Modification 1 – Basement and Construction Hours – Five Ways, Crows Nest (SSD-66826207-Mod-1)

This letter forms Deicorp's written response to the Department's letter dated 3 June 2025 requesting additional information for the assessment of the above modification application.

BASEMENT 5
& BELOW

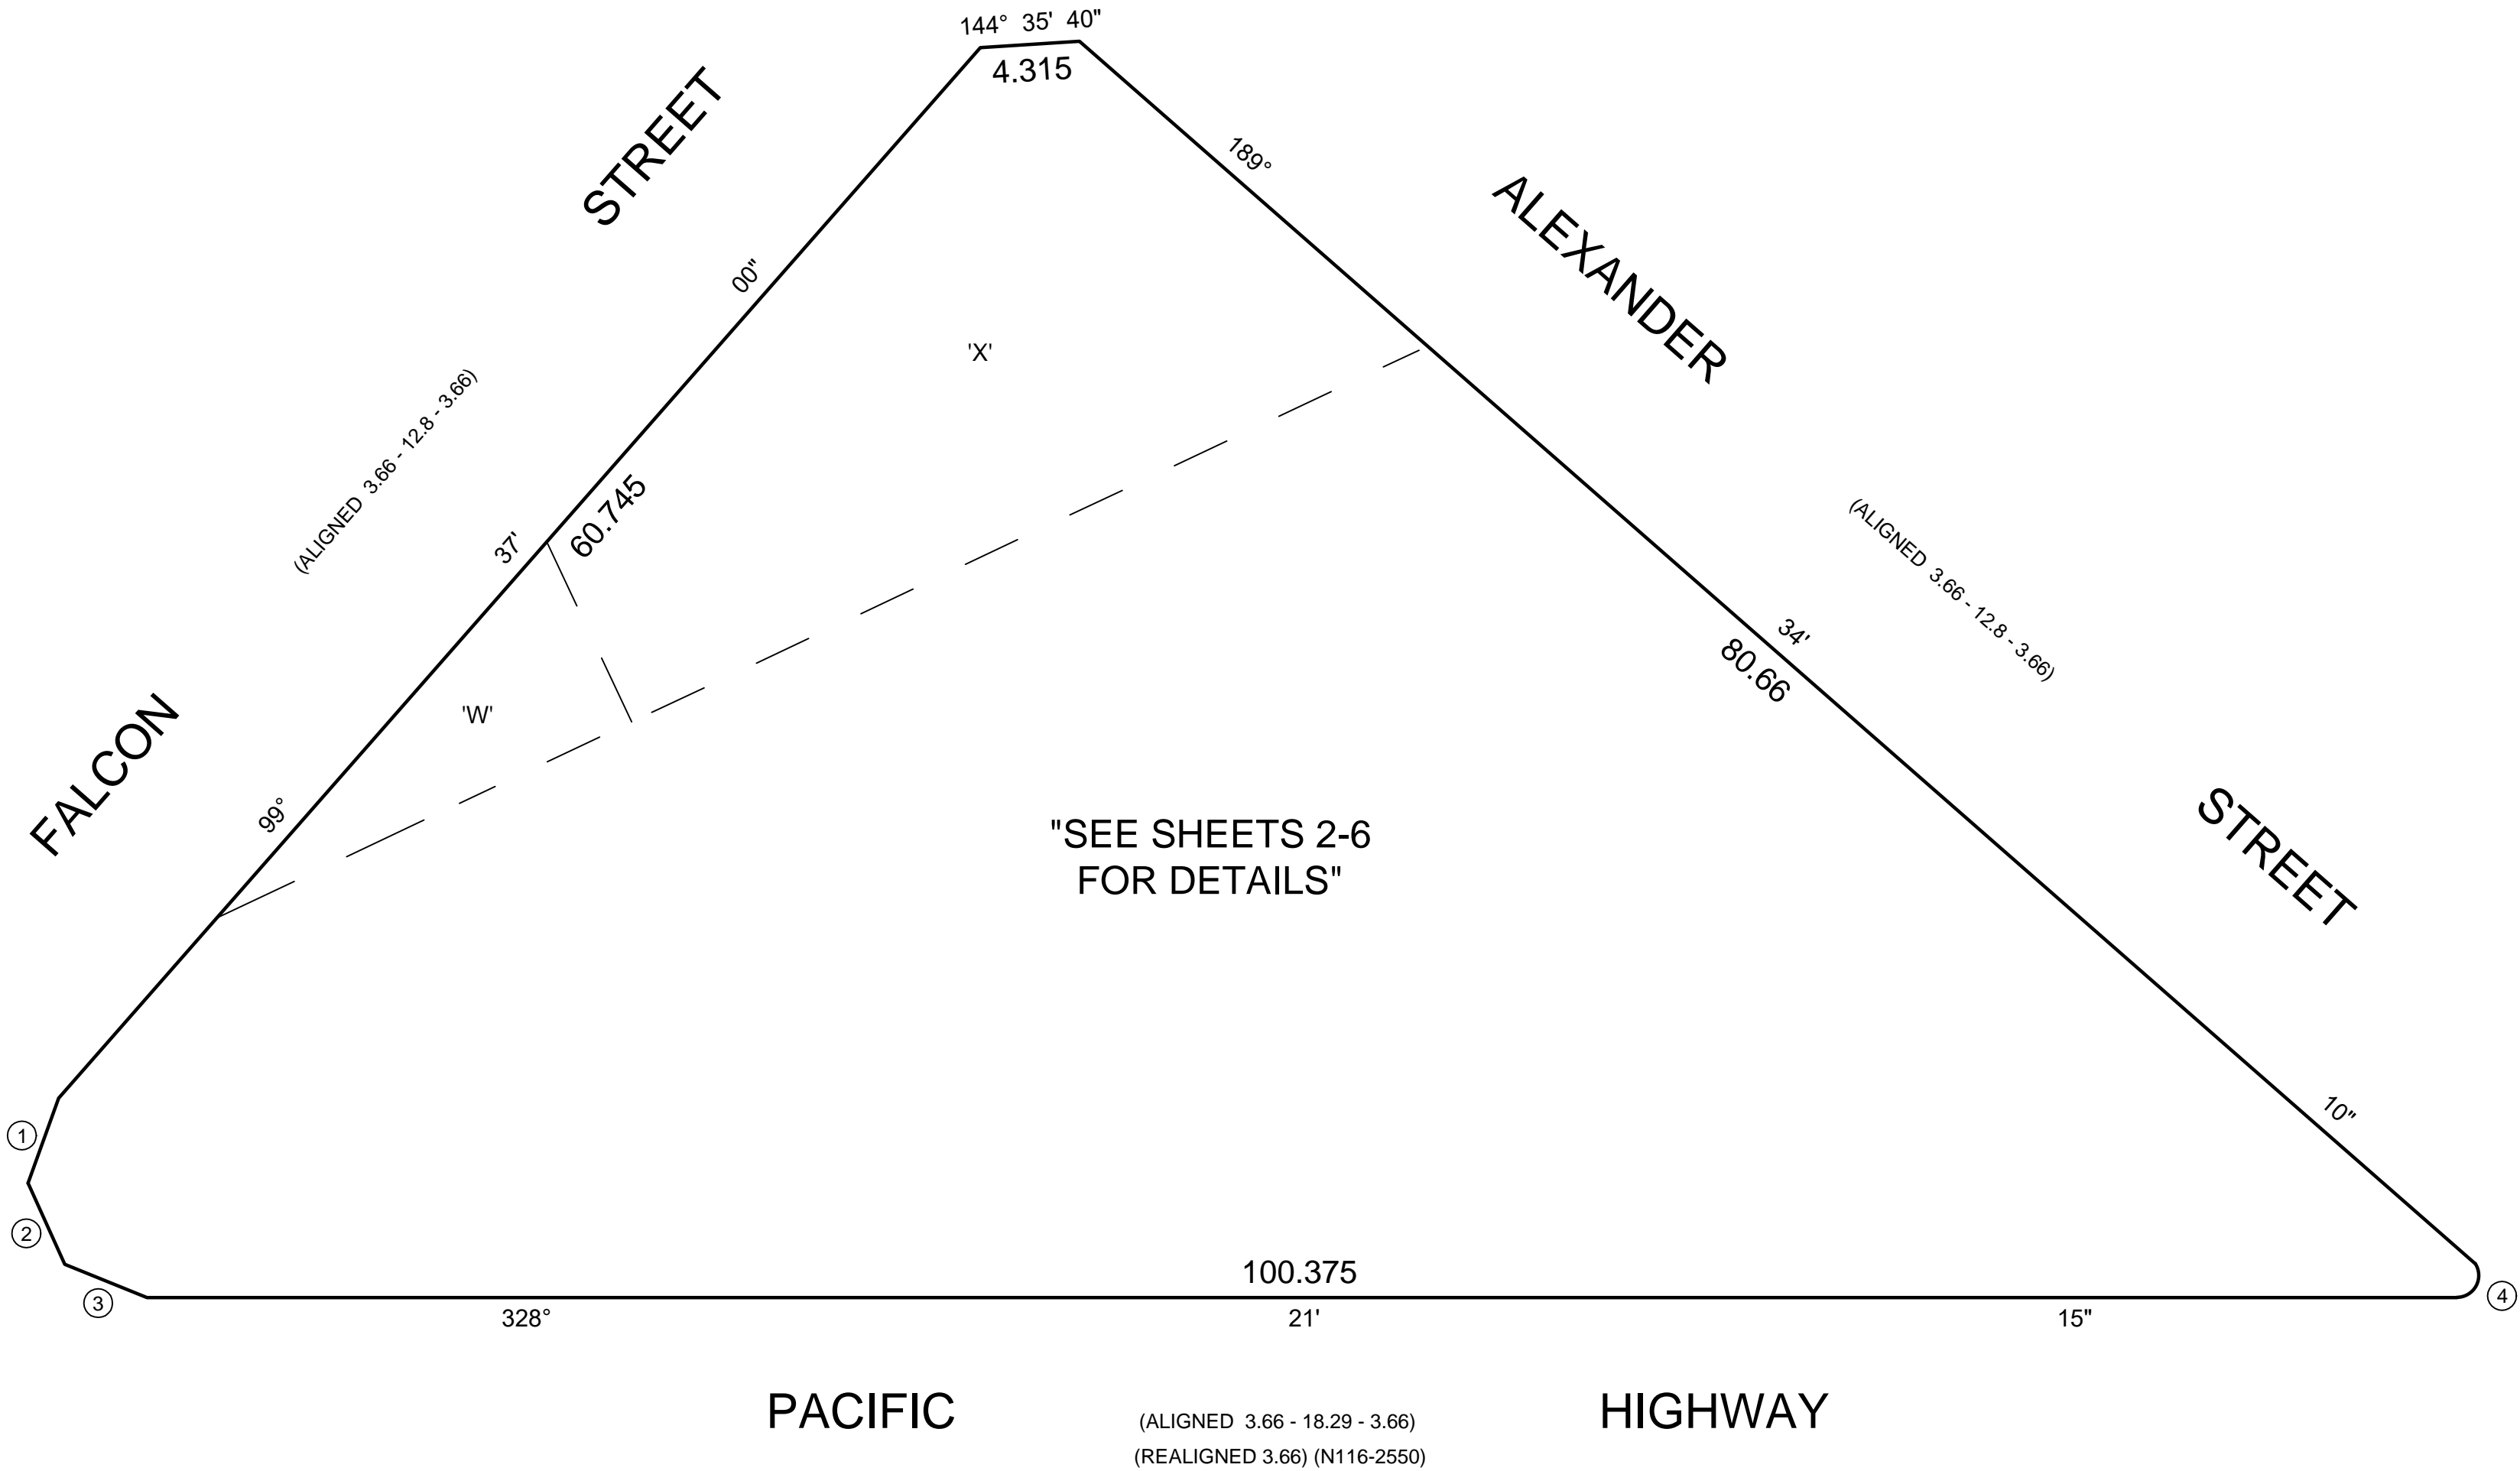
5. Provide an amended set of Stratum Plans to include the extent of RLs proposed below Basement 5 and ensure all structures below Basement 5 are captured (excluding Sydney Metro corridor).	The Stratum Plans do not include the extent of RLs proposed below Basement 5. The structures below Basement 5 (stormwater pump station and sewer pump station) are located within the residential stratum and these structures will be managed under a Building Management Statement (BMS). There is no utility or purpose in providing an RL for these structures on the stratum plans.
Swept path analysis

BASEMENT 2

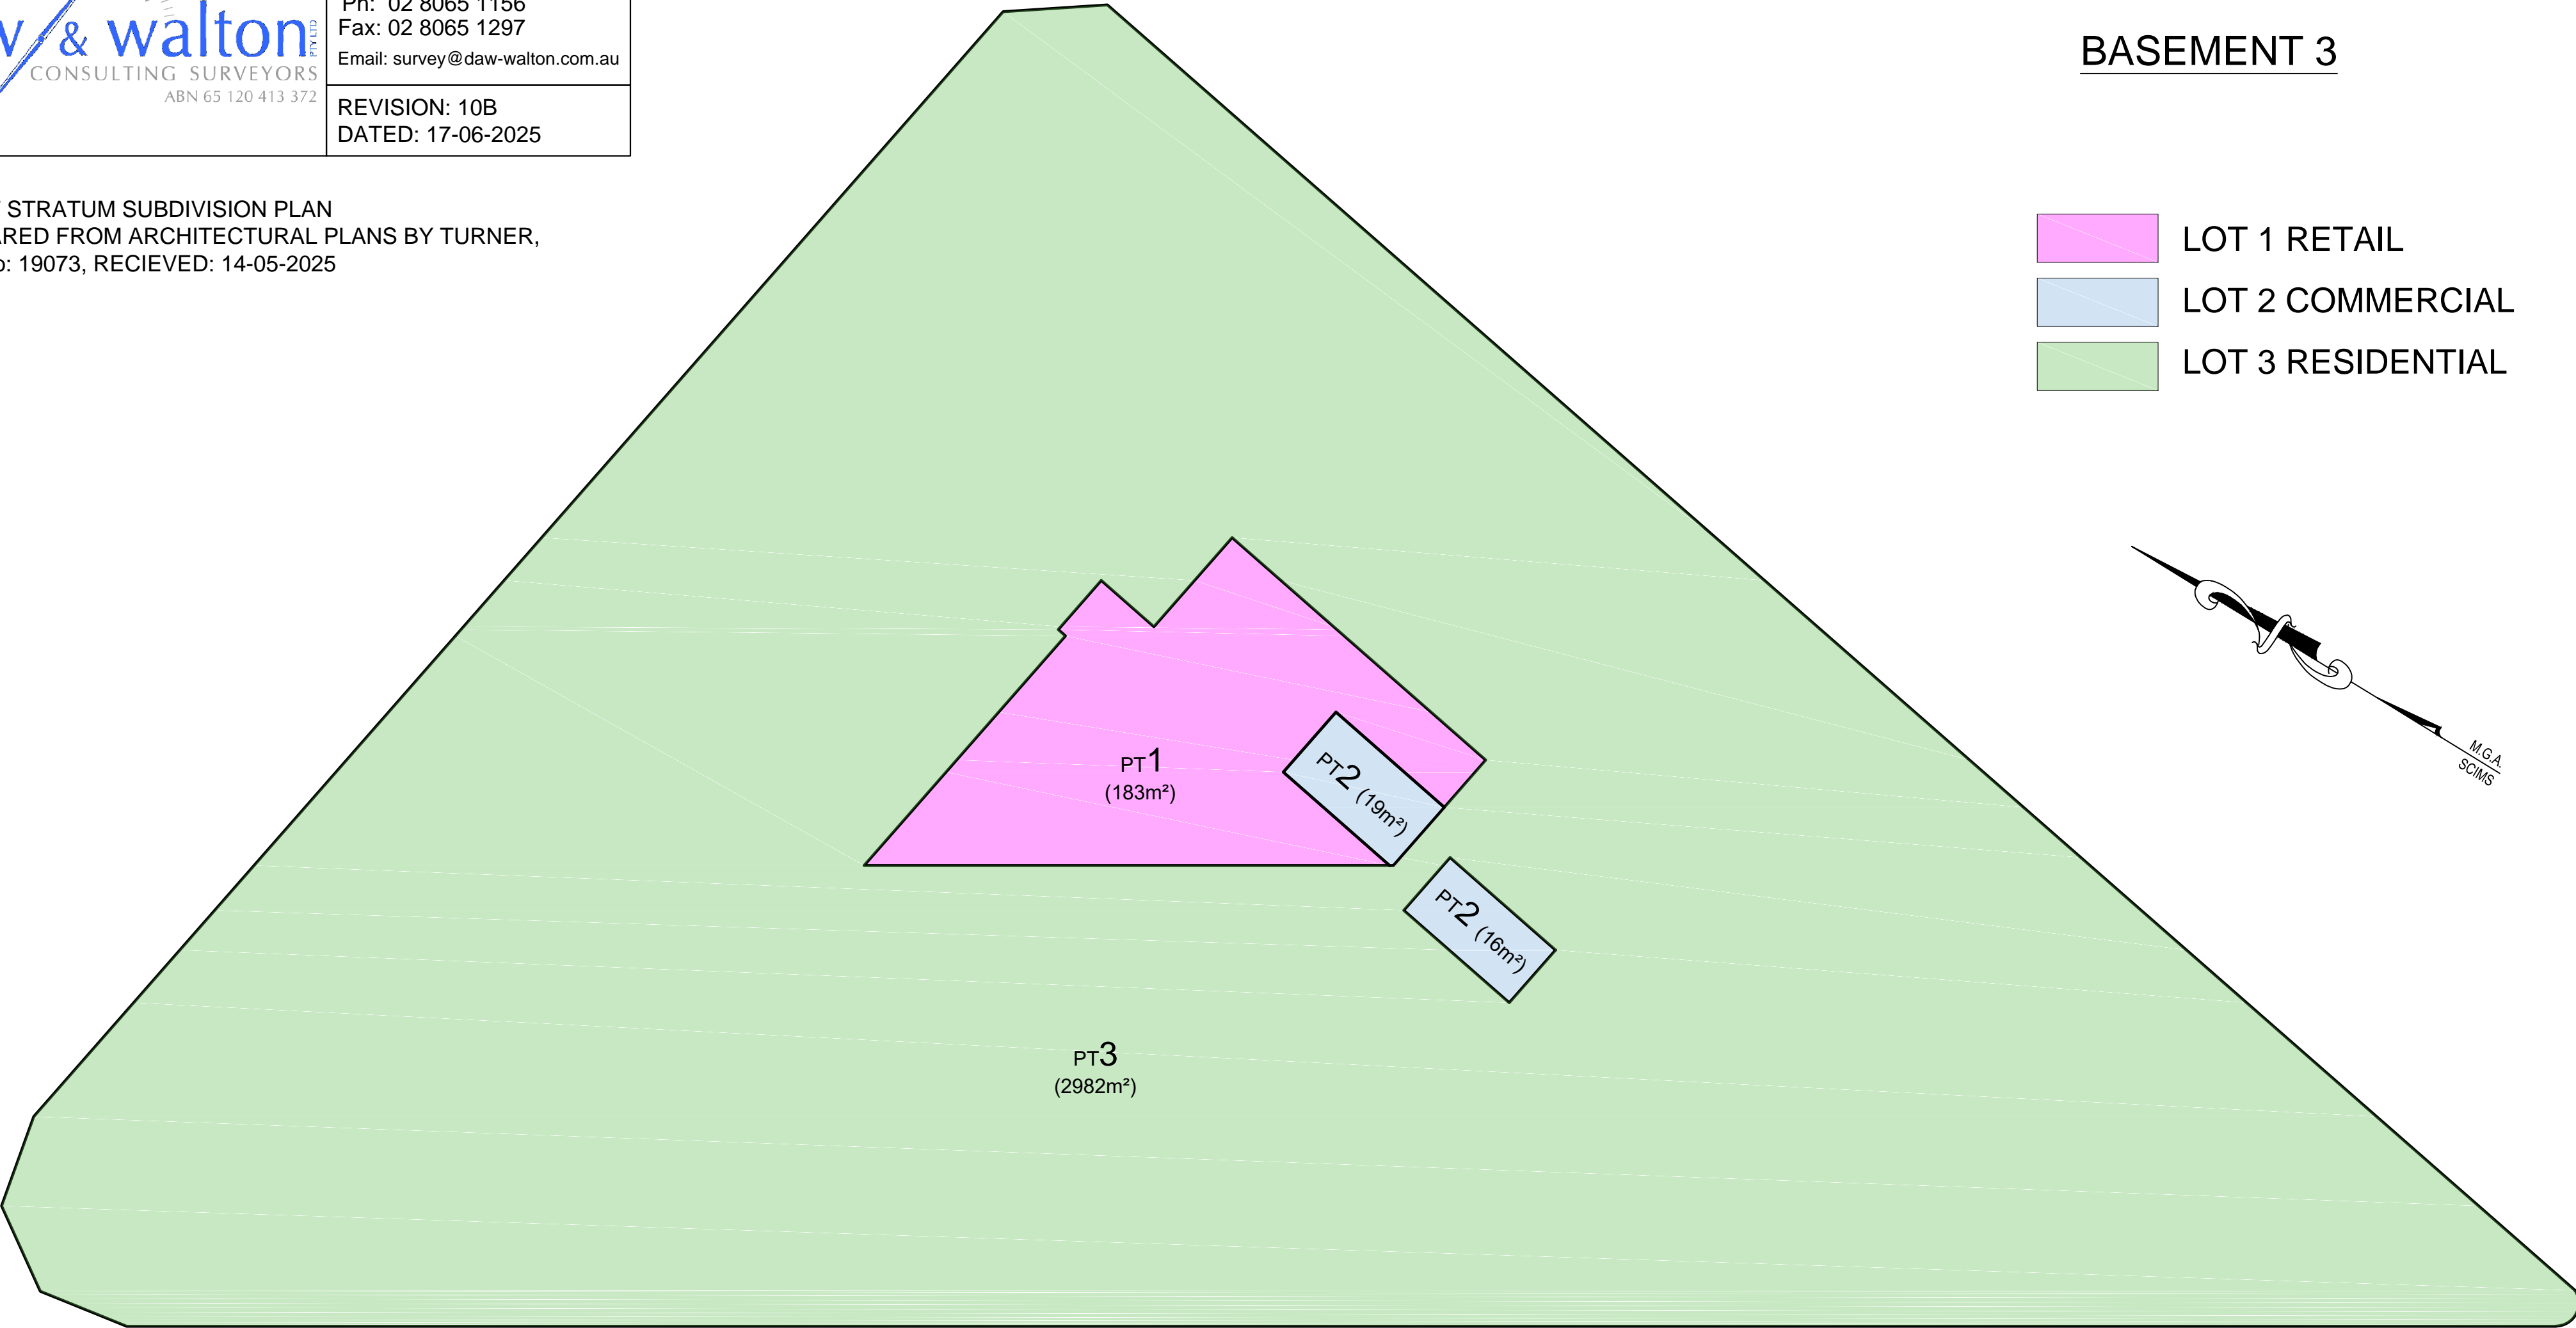
4. The submitted stratum plans are inconsistent with the architectural plans. For example, the stratum plan for Basement 2 has designated nine retail visitor bike spaces as part of Lot 2 Commercial, and some retail car parking spaces as part of Lot 1 Residential. You must amend the plans (either stratum or the architectural set) to remove all discrepancies.	Updated Stratum Plans are provided at Appendix 4 which are consistent with the architectural plans.
